From: Robert Findlay
Sent: 23 March 2015 16:04
To: Planning.Responses
Subject: FW: Planning Consultation on: LU/71/15/PL

APPLICATION LU/71/15/PL

Site Address: 10 St Catherines Road Littlehampton BN17 5HS

Description of Works: Conversion of Ground & First floor at the rear into two 2 bedroom flats.

SOUTH ELEVATION

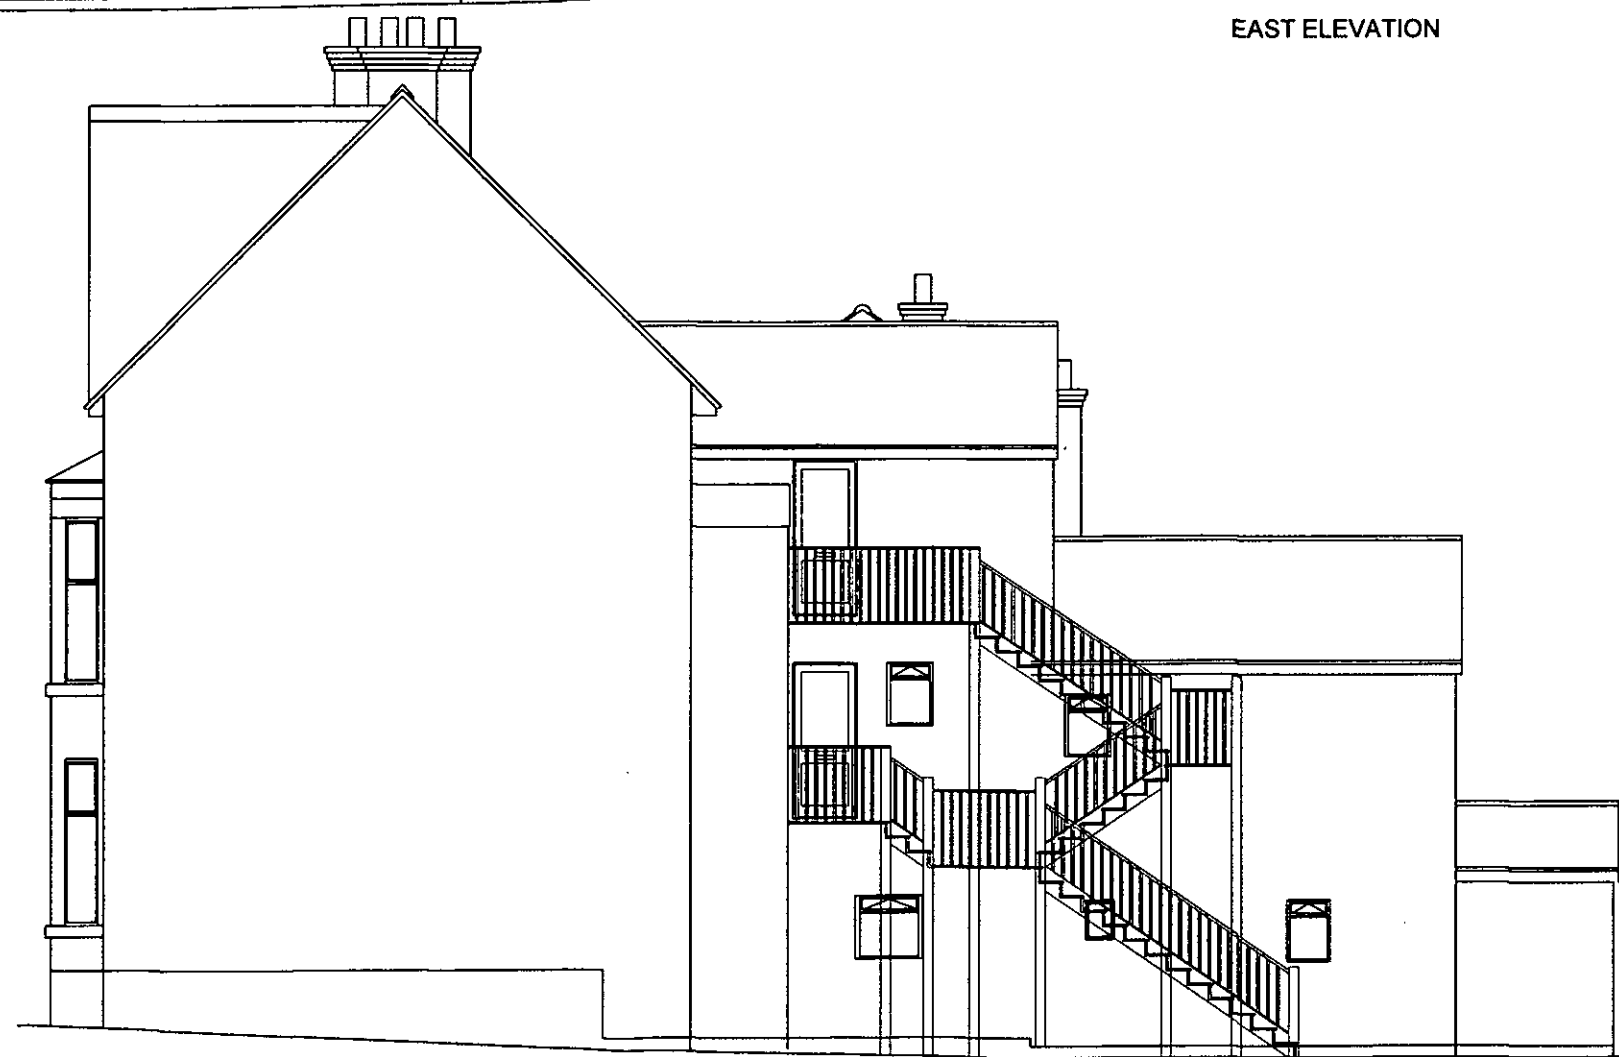
Windows on the south elevation are to have fire resisting glass

NEW GROUND FLOOR PLAN AND FLAT 1

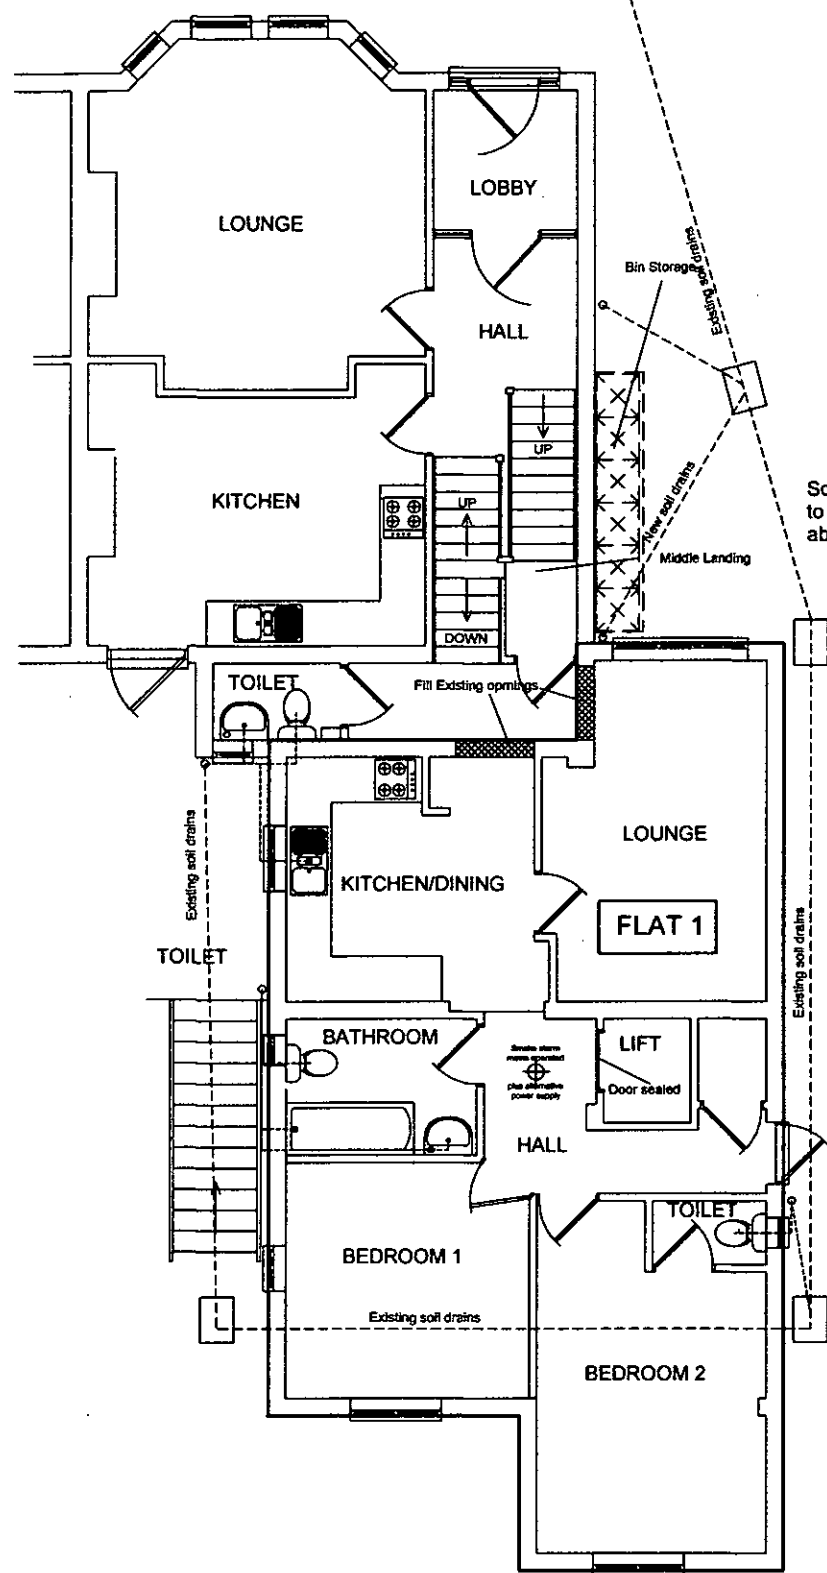
Flat 1

Means of escape from the living room is not acceptable as it is through another room of significant risk (kitchen) unless MOE windows are installed.

It is recommended that a smoke detector non interlinked is provided in the lounge with an FD30S door from the lounge to the kitchen, this would be in addition to the MOE windows.

An FD30S door to be provided to kitchen and to bedrooms.

NEW FIRST FLOOR PLAN AND FLAT 2

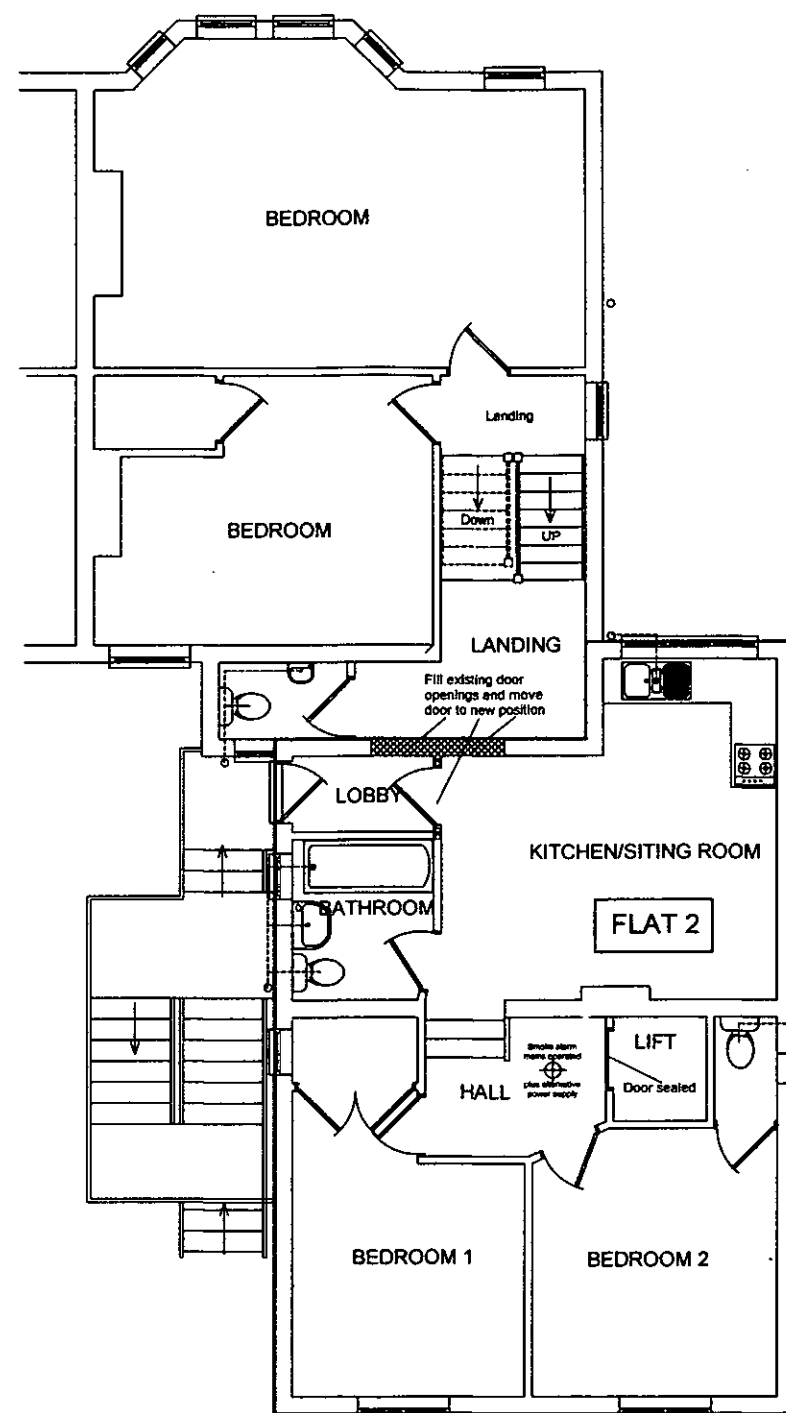
Flat 2

Means of escape from the 2 bedrooms is not acceptable as escape is through another room of significant risk (kitchen/living room.) unless MOE windows are fitted and the door separating the bedrooms from the kitchen living room are FD30S fire doors. The smoke detector proposed is to be retained in addition to the additional requirements.
